From: Simon Davis
Sent: 30 November 2018 10:58
To: Planning.Responses
Subject: FW: WSCC Planning Consultations on AL/116/18/PL and AL/117/18/PL

From: Katie Kurek [REDACTED]
Sent: 28 November 2018 16:36
To: Simon Davis
Subject: RE: WSCC Planning Consultations on AL/116/18/PL and AL/117/18/PL

I attach revised plan received from Scandia Hus produced in line with the WSCC requirements. Please note that this new revised plan is labelled as SP01 Rev C which needs to replace the reference in the applications to plan SP01 Rev B.

[illegible]

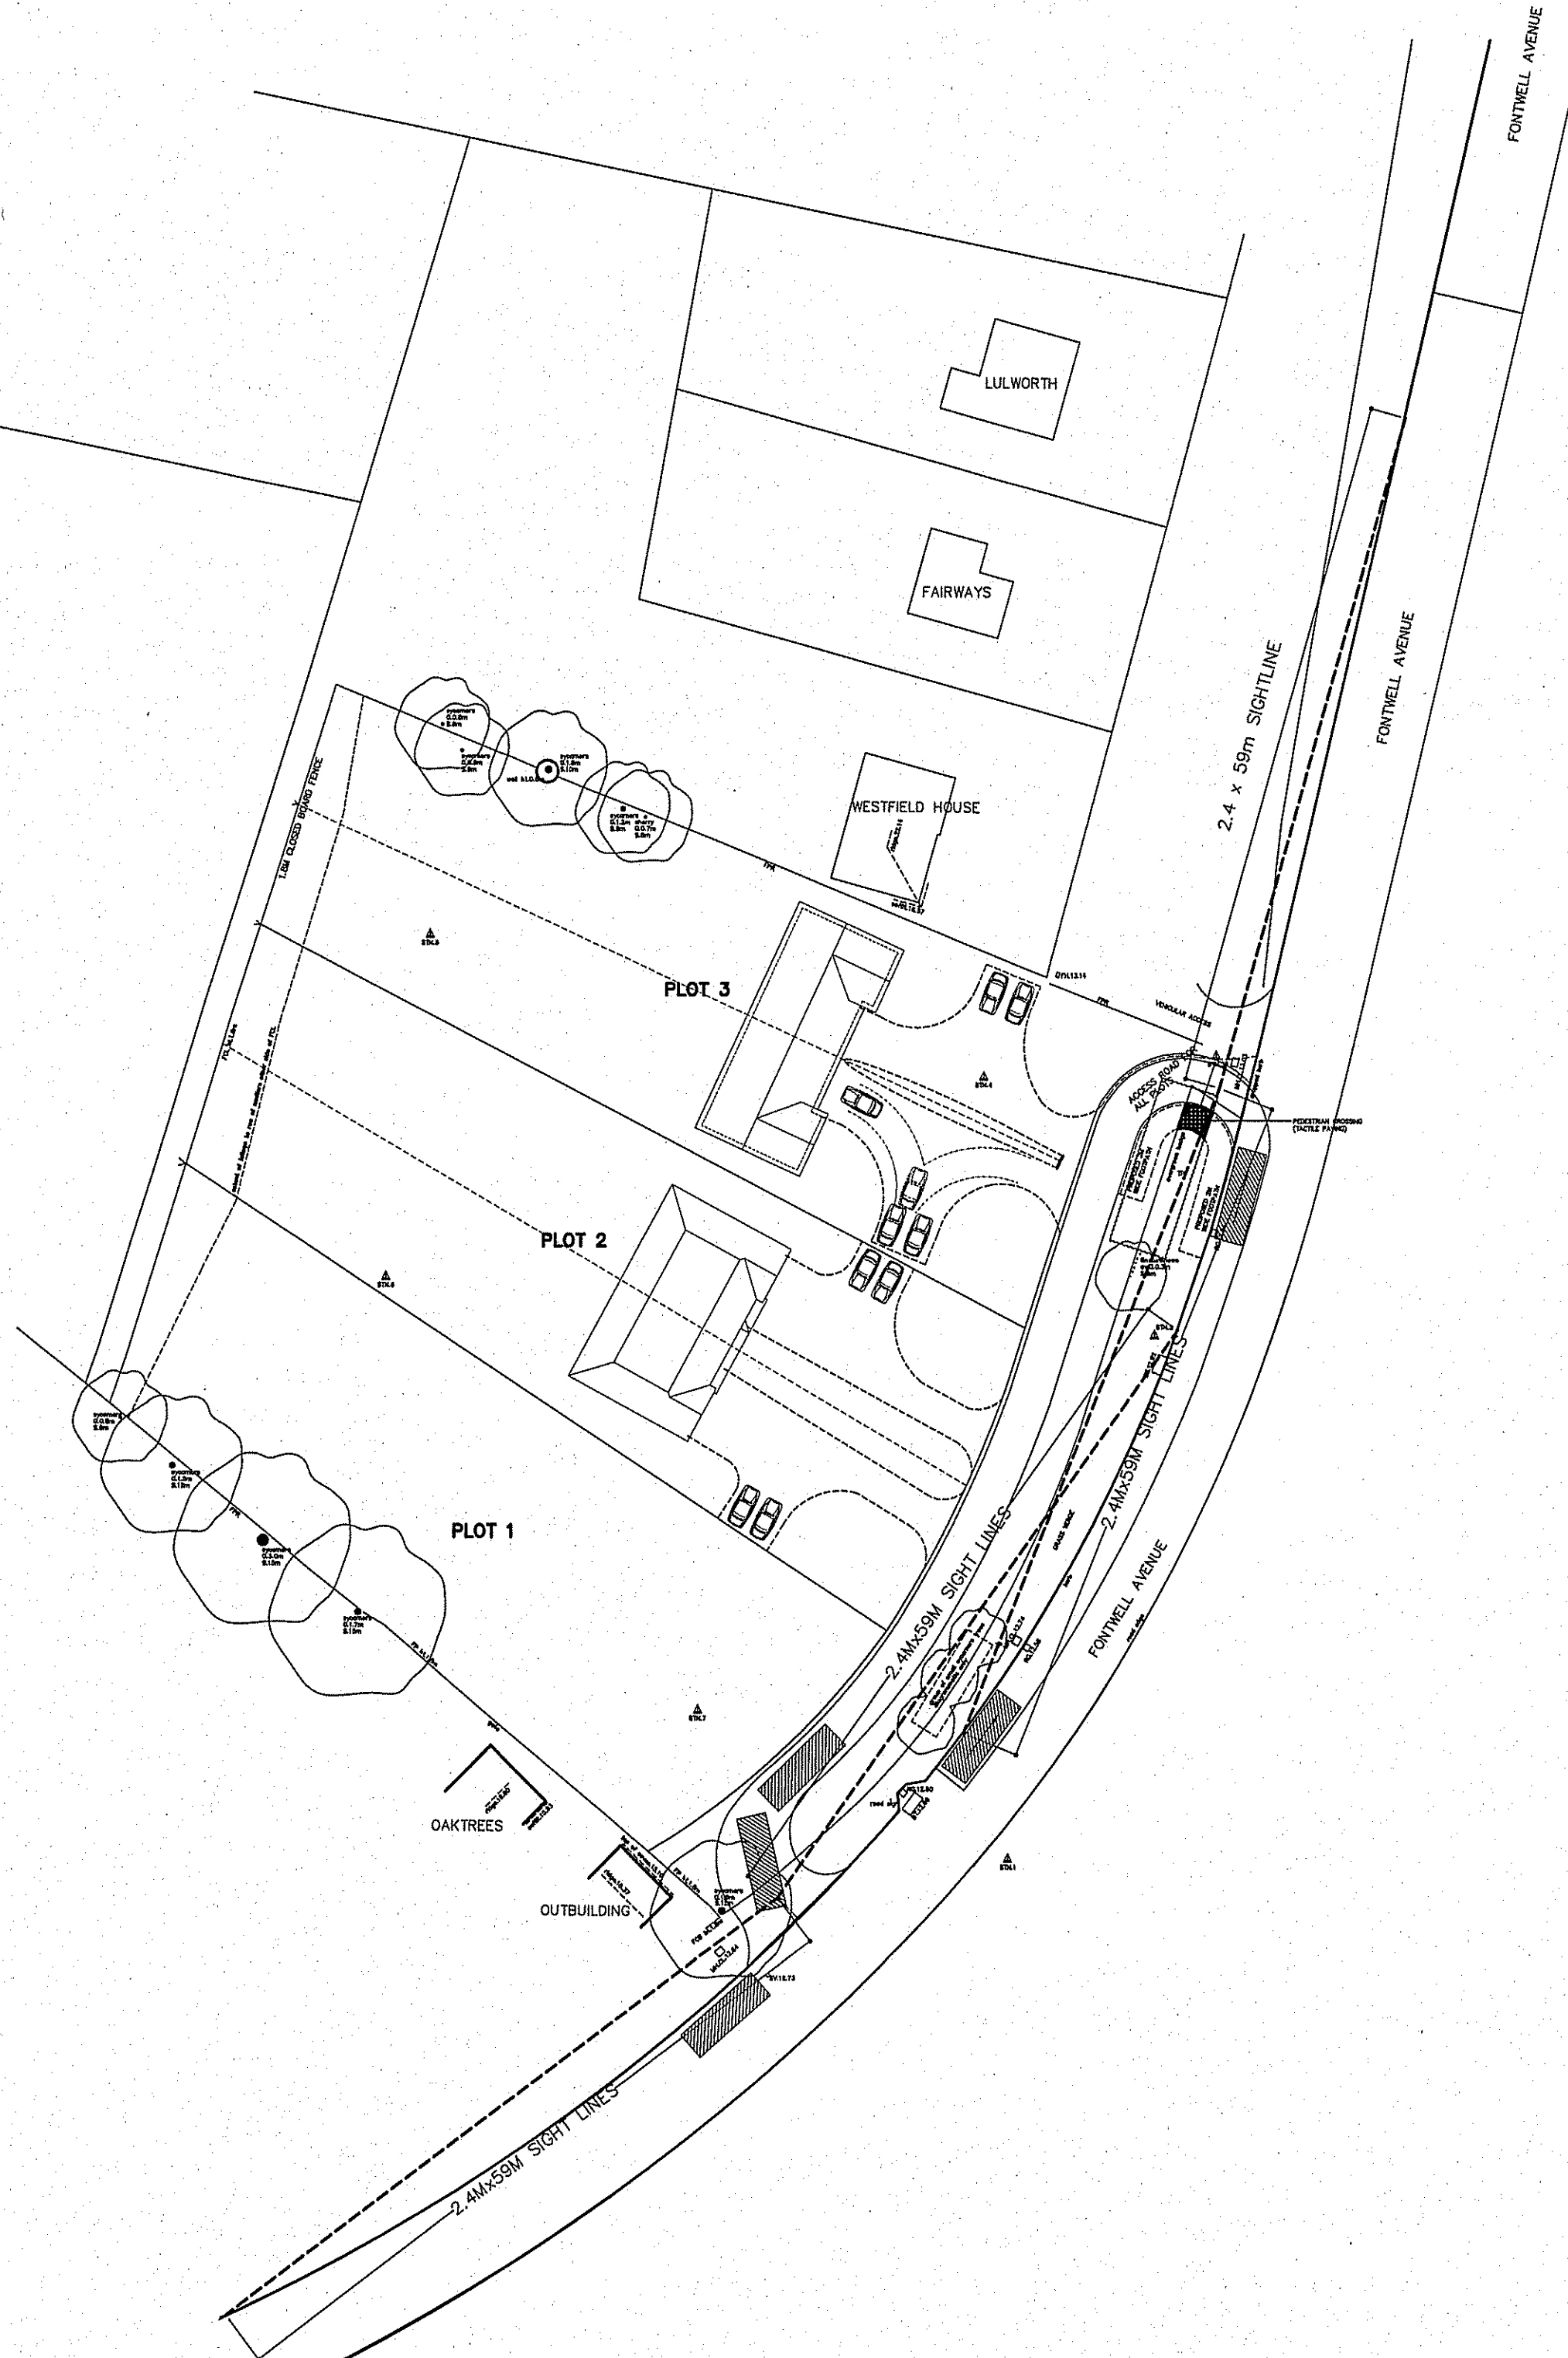
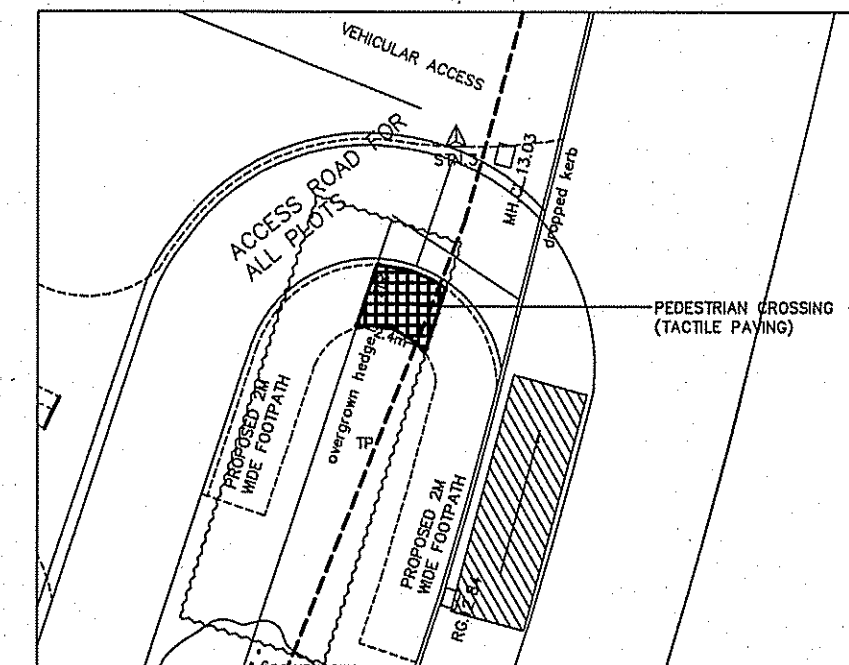
I appreciate the correct splays have now been indicated but ideally the red edge of the site should also be included so we can ensure that these pass through applicant maintained land and public highway only. I also note they have only indicated one of the pedestrian crossings on one side of the road whereas the approved site plan under AL/136/17 shows all four ped crossing points and proposed footway in greater detail. For consistency sake, this should be provided. The RGP drawings approved under AL/136/17 show this in clearer detail.
